BRIGHT PLAN CIVILS

24th May 2022
Planning Ref: P/153/21/RES
Our Ref: D1915

RE: CONSULTANT RESPONSE TO DRAINAGE COMMENTS

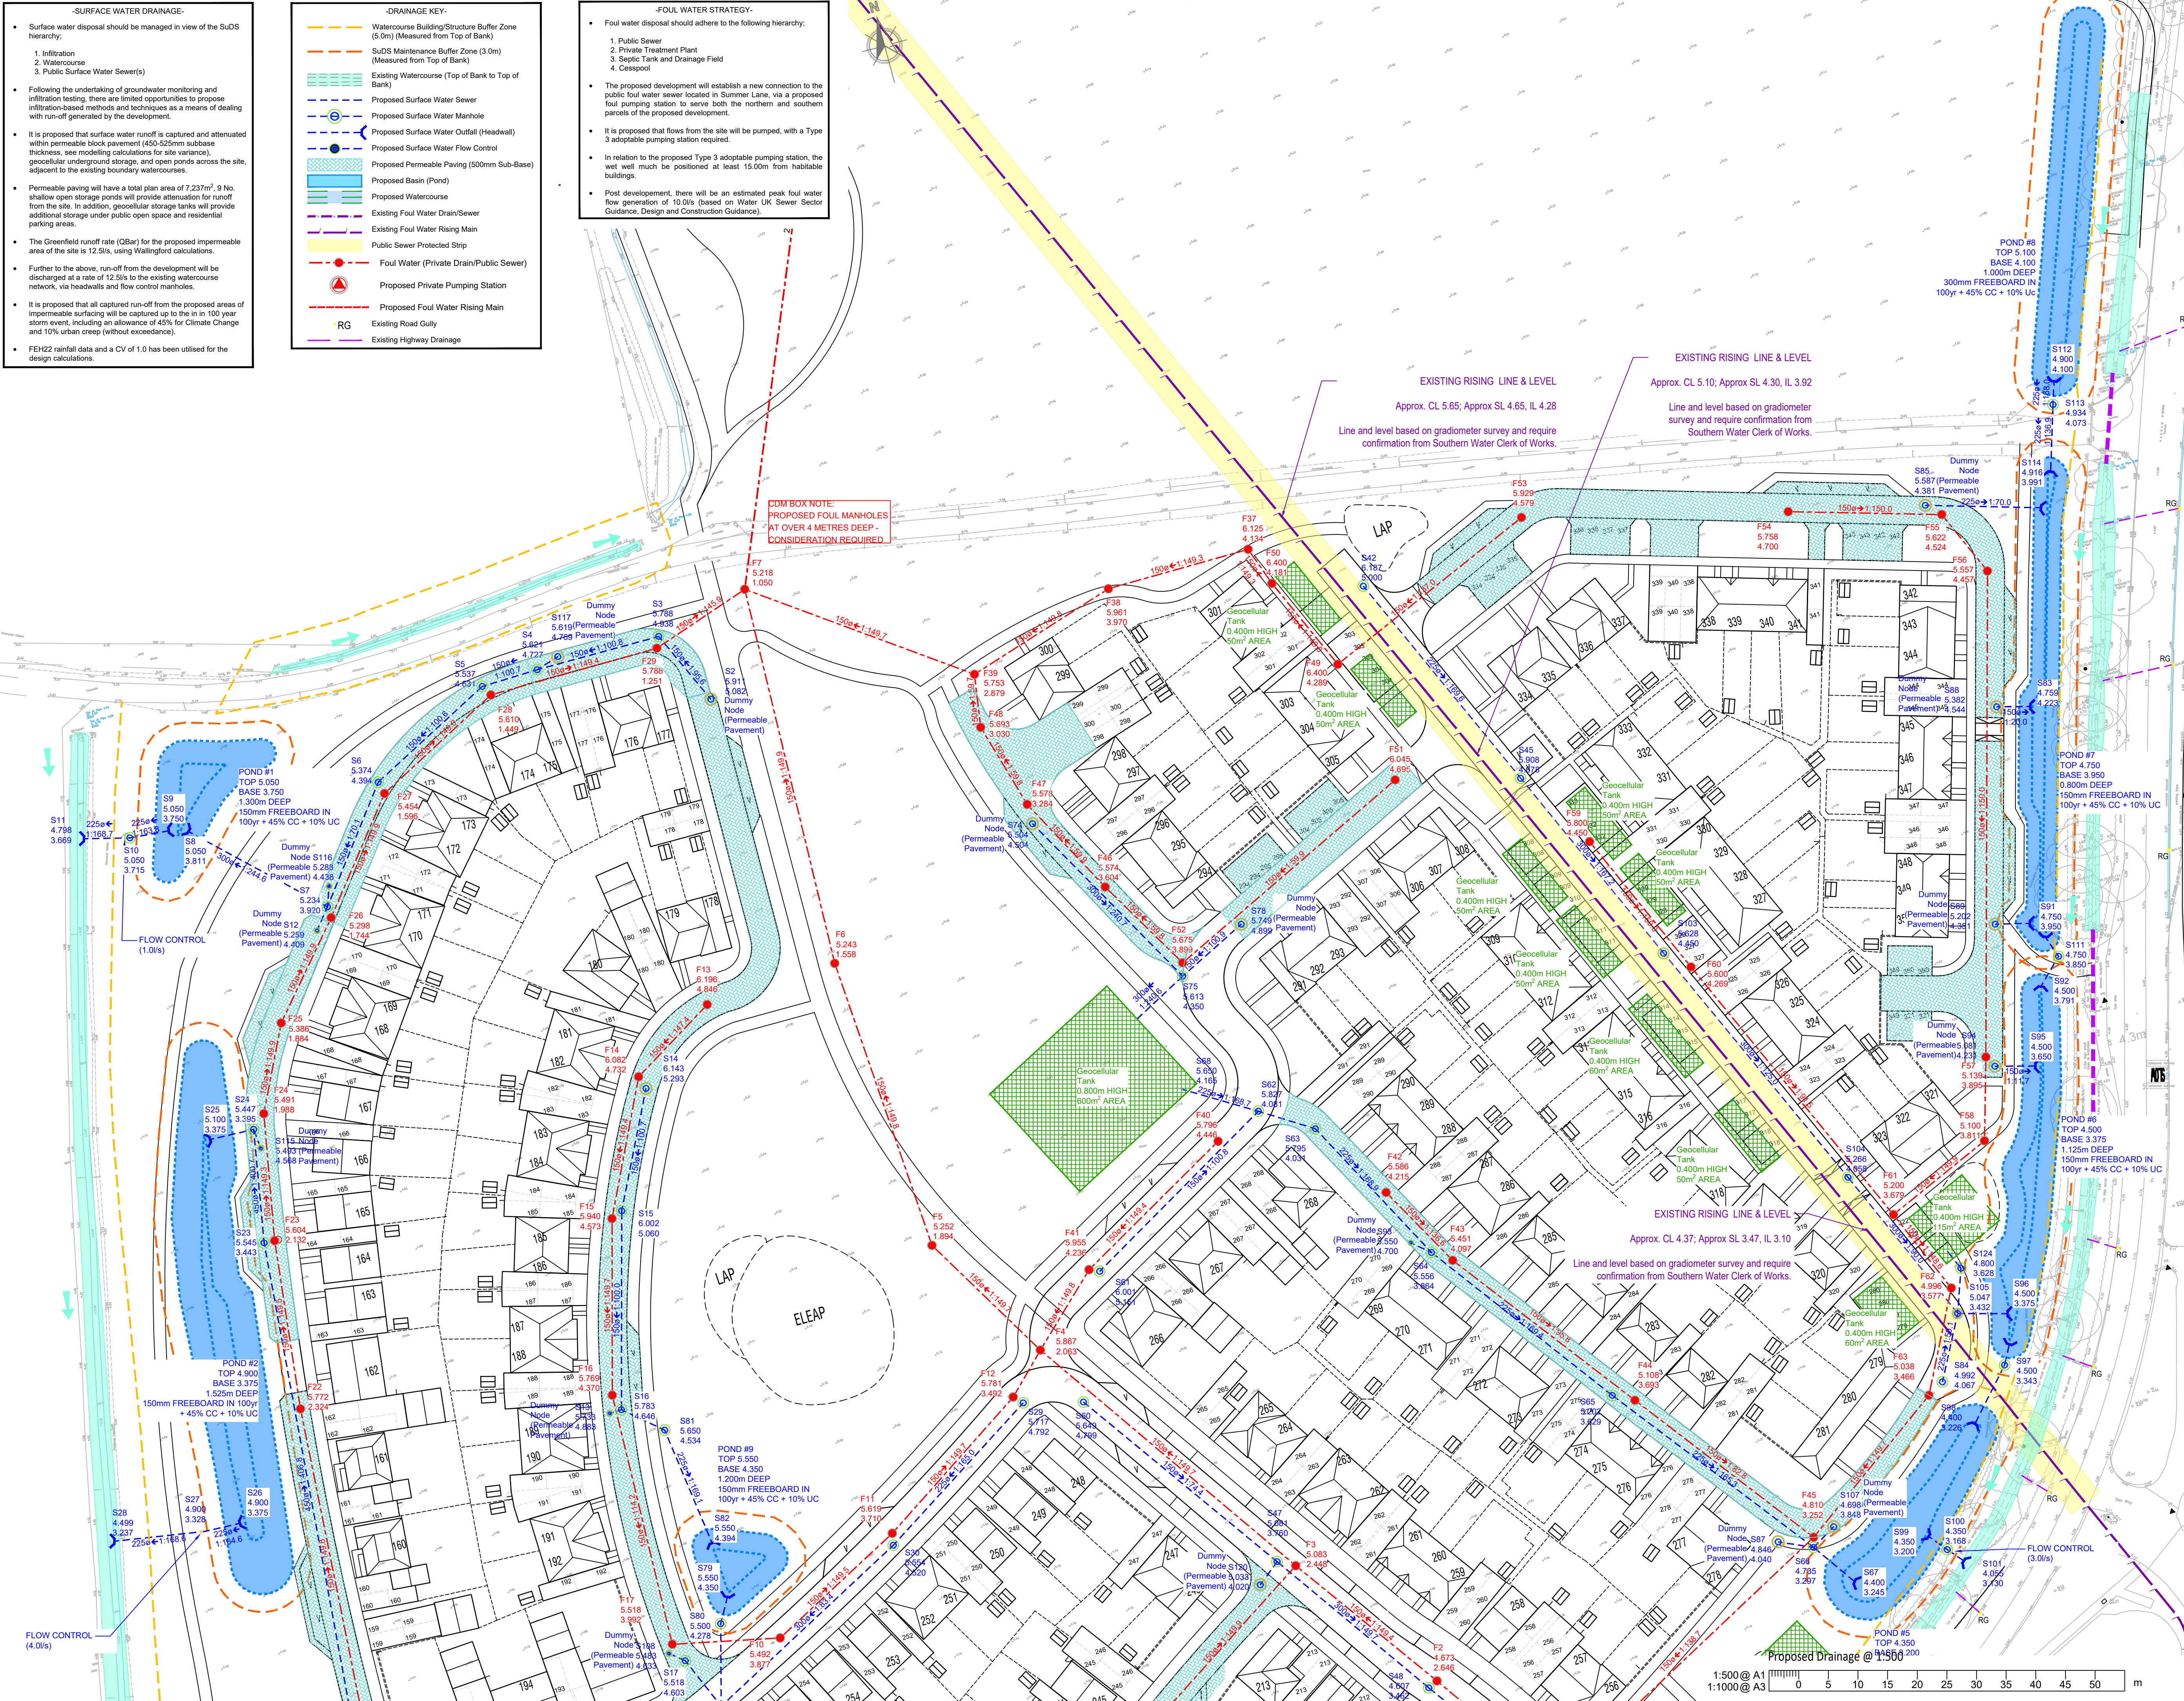
The proposed hardstanding area for the south site is 4.81 Ha – which would result in a Greenfield runoff rate of 16.8l/s. We have proposed a revised discharge rate of 16.0l/s, within this threshold, and have increased the pond volumes and permeable pavement area to allow for this.

The proposed hardstanding area for the north site is 3.04 Ha – which would result in a Greenfield runoff rate of 10.6l/s. We have proposed a revised discharge rate of 10.0l/s, within this threshold, and have increased the pond volumes and permeable pavement area to allow for this. (We have also included allowance in the model for a 1.0l/s additional flow rate and the catchment area in order to allow capacity for the unpermitted ditch along Summer Lane to be incorporated.)

2. We have taken your concerns into account and reworked the site level design in coordination with highways design and drainage design, as well as acknowledgement of potential flood risk to the site, using Civils 3D and Causeway Flow software to ensure a compliant design with sufficient surface water drainage falls. The site levels have been reduced to ensure significantly less ground raising and no more than 1.0m level raising across the site.

9. Drainage design has been updated to show Horn Lane watercourse improvements, as per this comment.
 10. Proposed basins have been reconfigured to ensure minimum 3.0m clearance from top of banks.

12. This is not viable, as we have already proposed significant areas of permeable pavement across shared surfacing, and this is unnecessary expense with the number of diffuser units, catchpits, and connections. It is also noted that other neighbouring LPA's have recently enforced permeable pavement areas to be within shared surfacing only, as private individual maintenance schemes are required in private driveways and cannot as easily be enforced. Permeable pavement extents within the road network have been expanded however.

13. Noted, FSR Data and CV of 1.00 used for revised design.
 14. Noted, surcharged outfalls included to top of existing watercourse bank levels.
 15. Noted.
